Application for a non-material amendment following a grant of planning permission. Town and Country Planning Act 1990

ERECTION OF SINGLE STOREY FRONT AND TWO STOREY SIDE & REAR EXTENSIONS

2024/62/93092/E

CHANGE OF EXTERNAL WALL FINISH FROM RENDER TO BRICK TO MATCH EXISTING TO REAR, SIDE & PART FRONT ELEVATION.

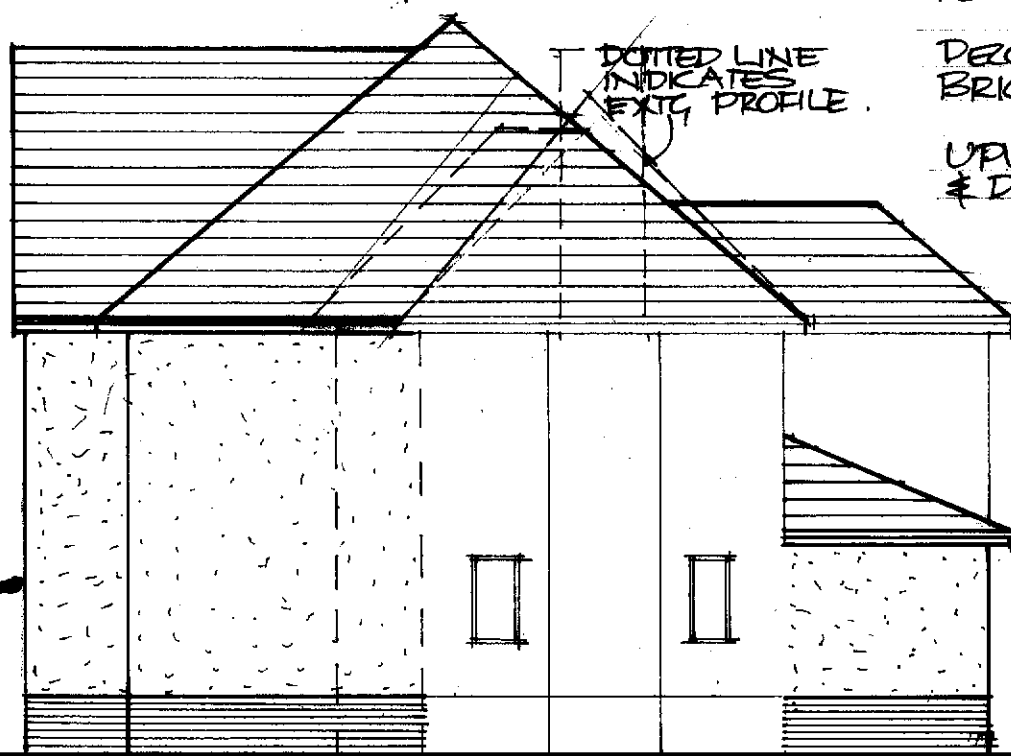
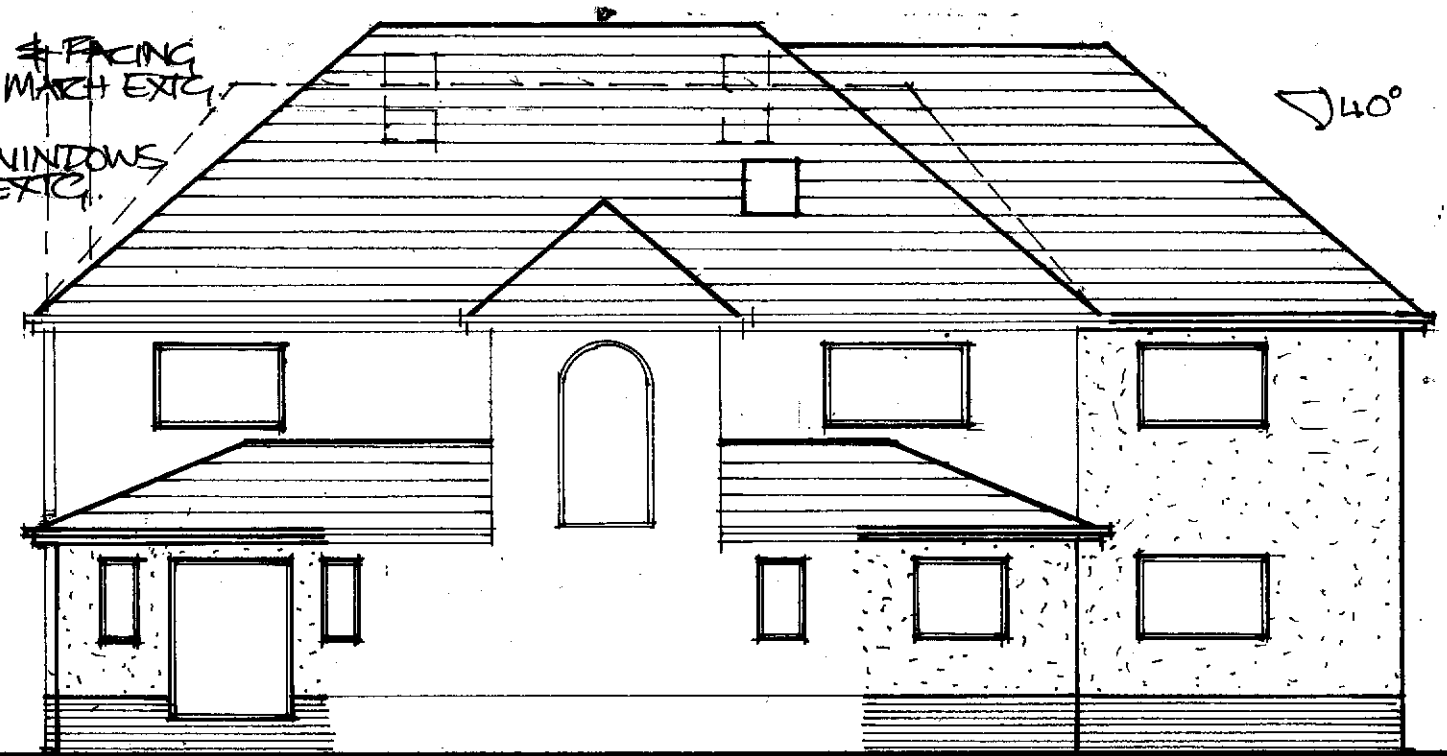
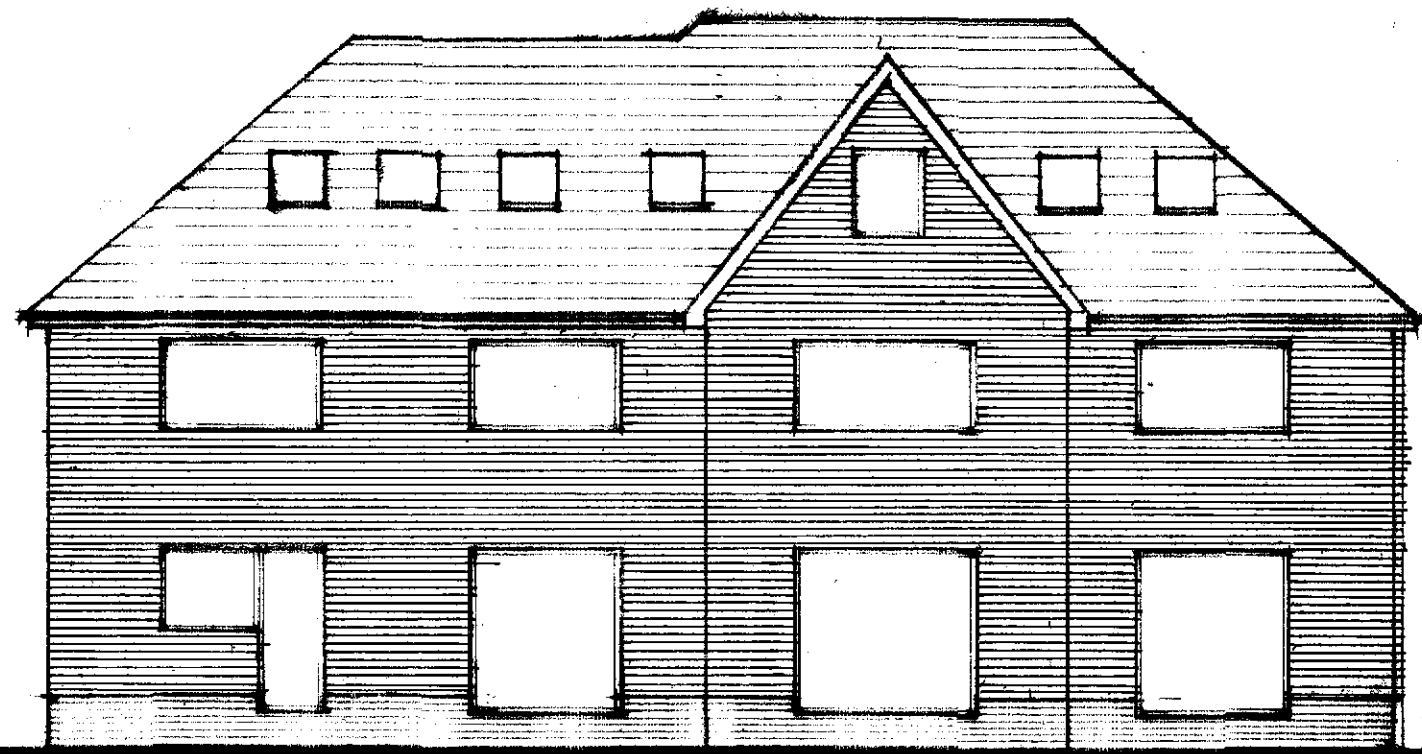
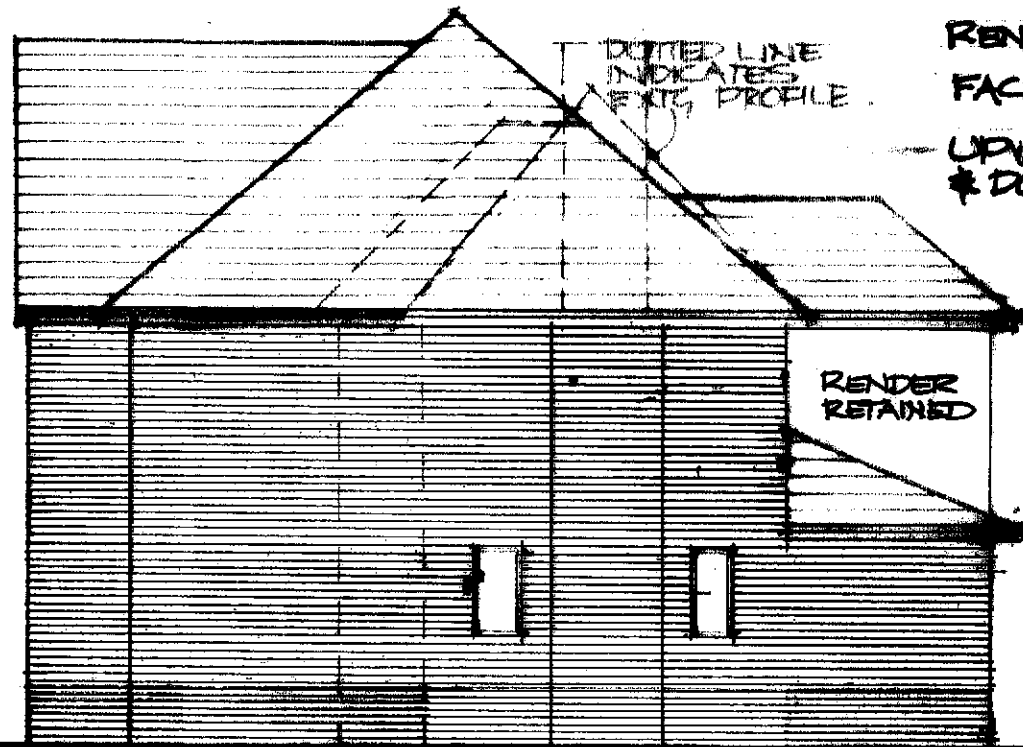
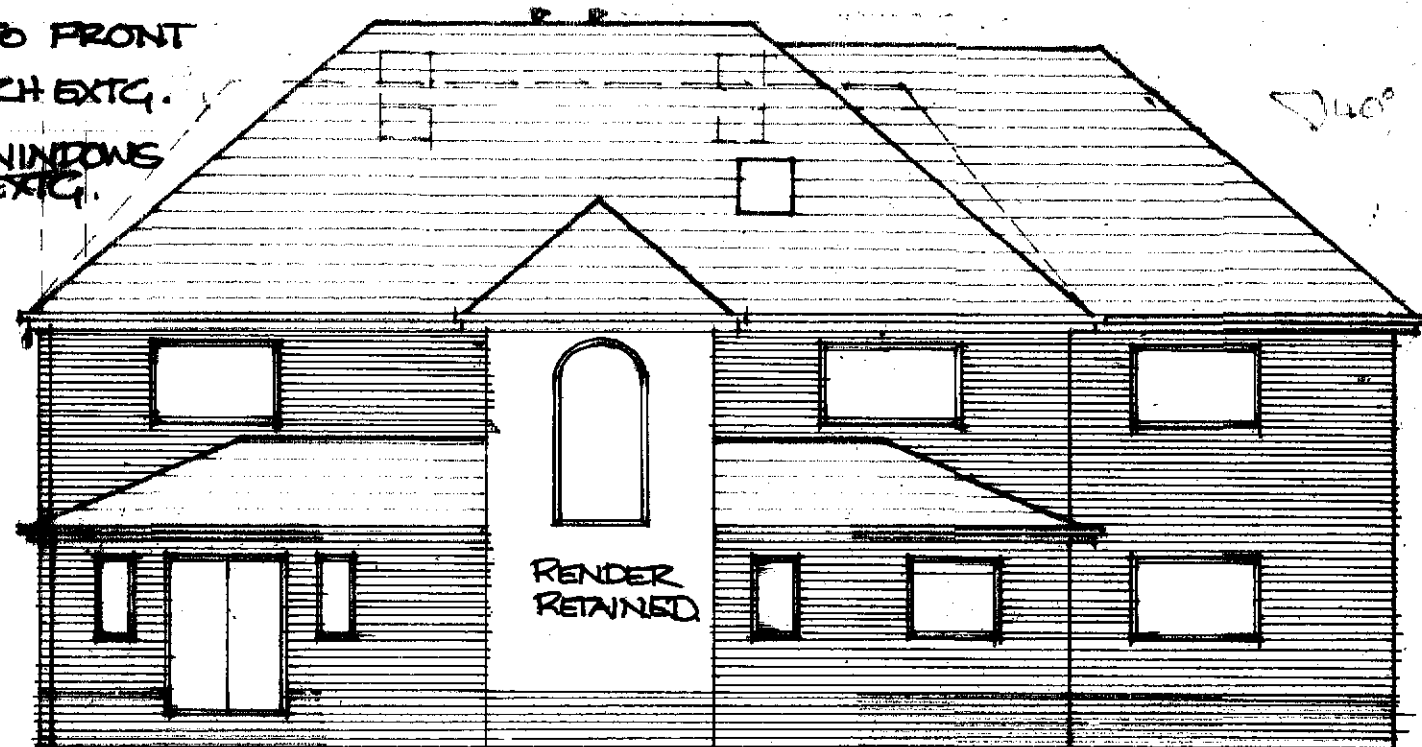
BRICK TO MATCH SURROUNDING PROPERTIES
REDUCE FUTURE MAINTENANCE (REPAINTING, CRACK REPAIRS ETC)
EXISTING RENDER IS ALREADY CRACKED.
NEW WALLING TO SIDE, REAR & FRONTAGE SIMPLIFY CONSTRUCTION.

CLH/304

CLH/304 REV A.
